KIRKLEES METROPOLITAN COUNCIL INVESTMENT & REGENERATION SERVICE

DELEGATED DECISION TO DETERMINE PLANNING APPLICATIONS

Reference No:	2023/62/93291/W
Site Address:	18, Saint Francis Gardens, Fixby, Huddersfield, HD2 2EU
Description:	Erection of single storey extension and raised terrace
Recommending Officer:	Laura Yeadon

Opaque frosted glass film, Grade 4
 Manufacturer - MetaMark
 Product - M7 Dusted crystal
 Dome pattern – Shutterstock , Vector ID Stock Vector ID: 1022517658

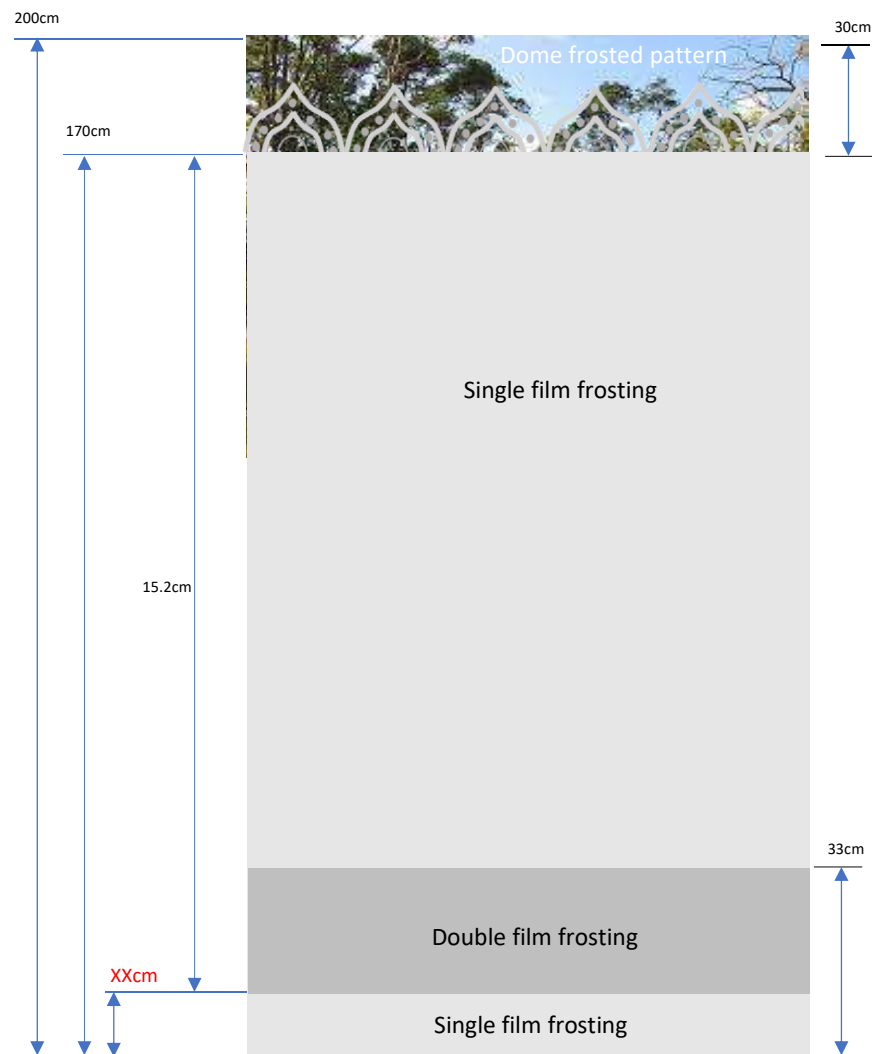
Following the committee site visit undertaken on 1st February 2024, and as discussed at the subsequent meeting of the same date, it was noted that obscure treatment of the windows with an affixed film had been undertaken. (condition 2 applies).

2. All glazing within the eastern, south-eastern and southern elevations of the single storey extension shall be retained with obscure glazing or a permanently affixed film which achieves a minimum privacy rating

Grade 4. This shall be retained at a height of 1.7m when measured from the finished floor level in accordance with the specification detailed upon drawing ref 05 Rev A.

Confirmation was provided by the applicant's agent that the obscured film affixed to the windows is of a height of 1.7m above floor level, is at a Grade 4 level of obscurity, the manufacturer is 'MetaMark' and the specific product is 'M7 Dusted crystal' as set out in the Opaque treatment details received 7th December 2023.
